OXFORDSHIRE COUNTY COUNCIL'S RESPONSE TO CONSULTATION ON THE FOLLOWING DEVELOPMENT PROPOSAL

Application no: 16/00193/REM-2

Proposal: Reserved matters application to 06/00967/OUT - Access, layout, scale, landscaping and appearance of proposed dwelling on parcel KM5 comprising of 90 No. dwellings

Location: Land South West Of Bicester Adjoining Oxford Road And Middleton Stoney Road Bicester Oxfordshire

DRAWING NUMBER	REVISION
57699 - 99

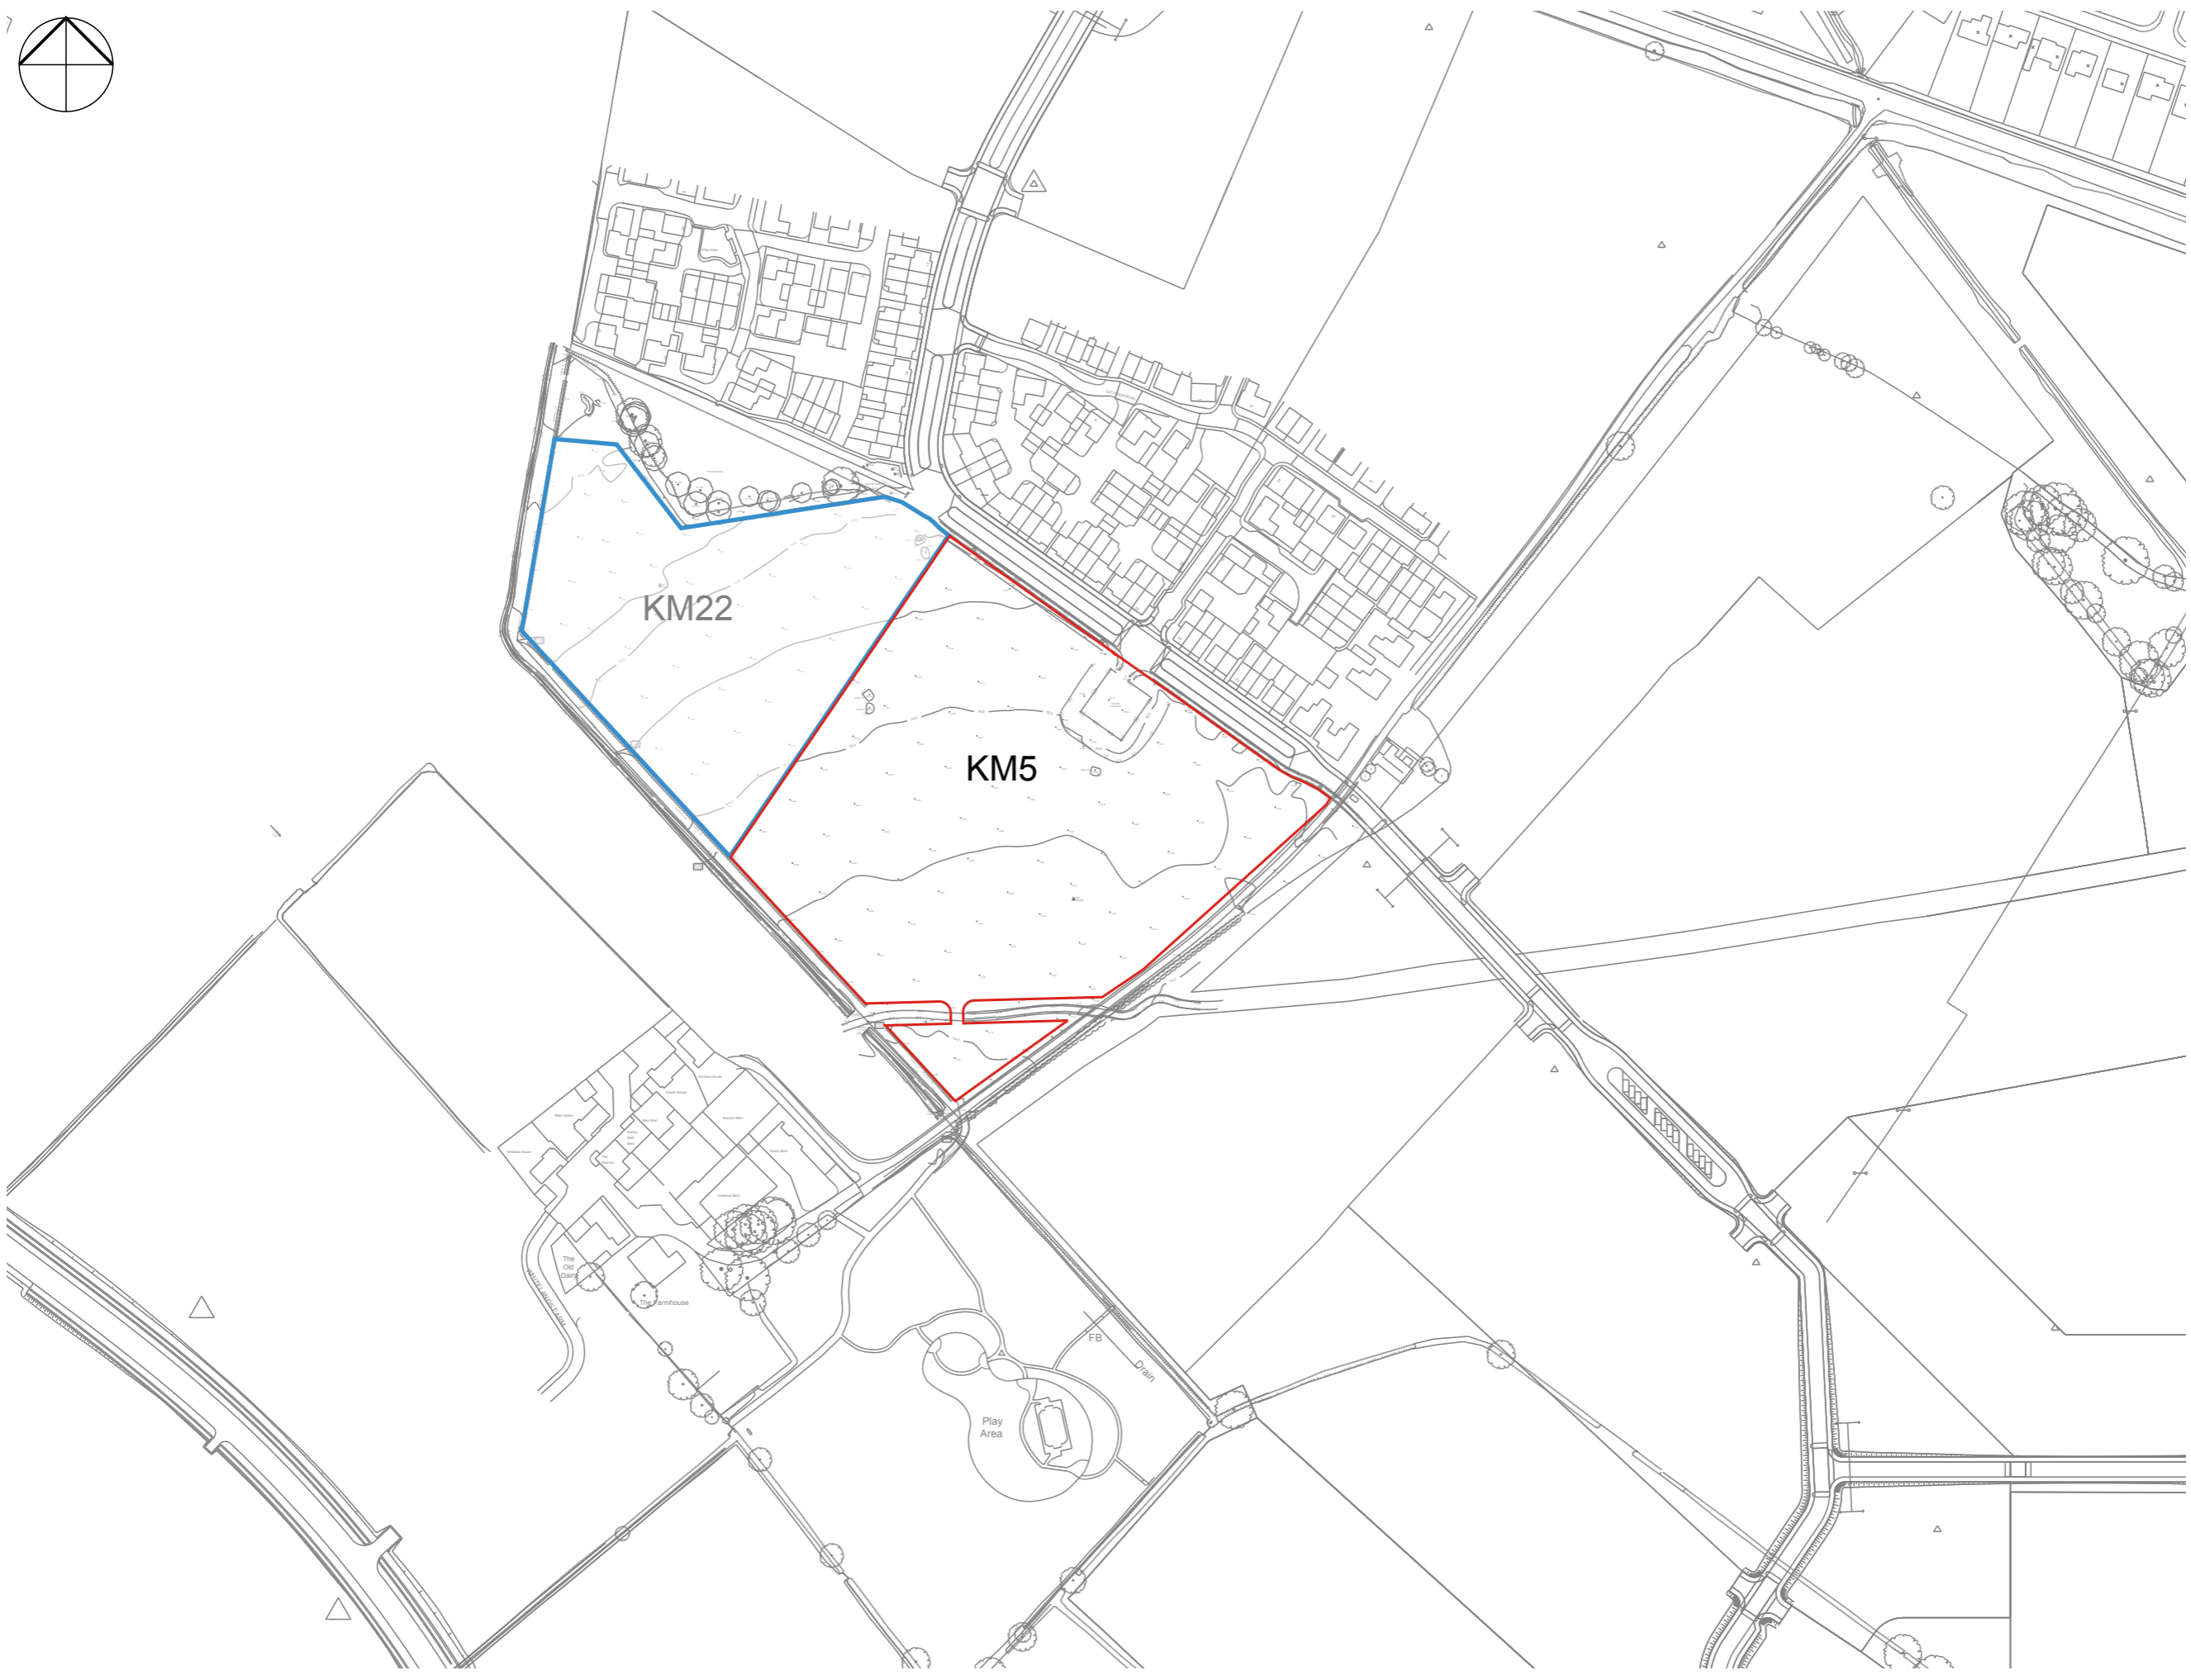
For parcel KM5, the developer has now reduced visitor parking spaces to 11. Given that there were a total of 16, this is an inadequate number, when measured against our maximum parking standards that suggest there should be 36 spaces. Given that 49 out of the 90 dwellings (54%) are going to be 4 bedrooms, I believe requesting that the developer add more visitors' parking into this parcel is justified. If not enough parking is provided it could encourage on street parking in inappropriate locations. This will cause problems for larger vehicles needing to access the dwellings, as well as quicker depreciation of the grass strips dotted around the site.

I have particular concerns about making sure enough visitor parking is provided around the Marker Building, where there is one parking space per flat, as potentially this could have an impact upon the landscaping and pedestrian realm, where cars park on the street or on grass areas.

I still have concerns about the tree on the southern side of the LAP, which is in the vision splay. I do note the species of tree from the Landscape Strategy Masterplan and acknowledge the narrower girths that these have, however, it would still be advisable to move this tree northwards slightly, completely out of the vision splay.

There is another tree of the same species to be placed in the vision splay of the junction between the central mews (running NE-SW) and the side street, which, for safety purposes, should be moved further in from the carriageway, or removed altogether.

A service strip needs to be provided around the turning head adjacent to plot 17. This service strip needs to be 800mm in width and is important, as it allows us to carry out highway maintenance works and helps in the provision of lighting columns and utilities. This would ensure that there is a clear delineation between private land and the highway. If not built to OCC standards, it may not be adopted under a s38 agreement.

The vehicle tracking that has been submitted for a 10.5m refuse truck is very tight when it manoeuvres around the LAP area, due to the visitor spaces. The carriageway and footway are a levelled surface here, so any vehicle will not be mounting the kerb, however, care will need to be taken to ensure larger vehicle movements are not conflicting with pedestrians.
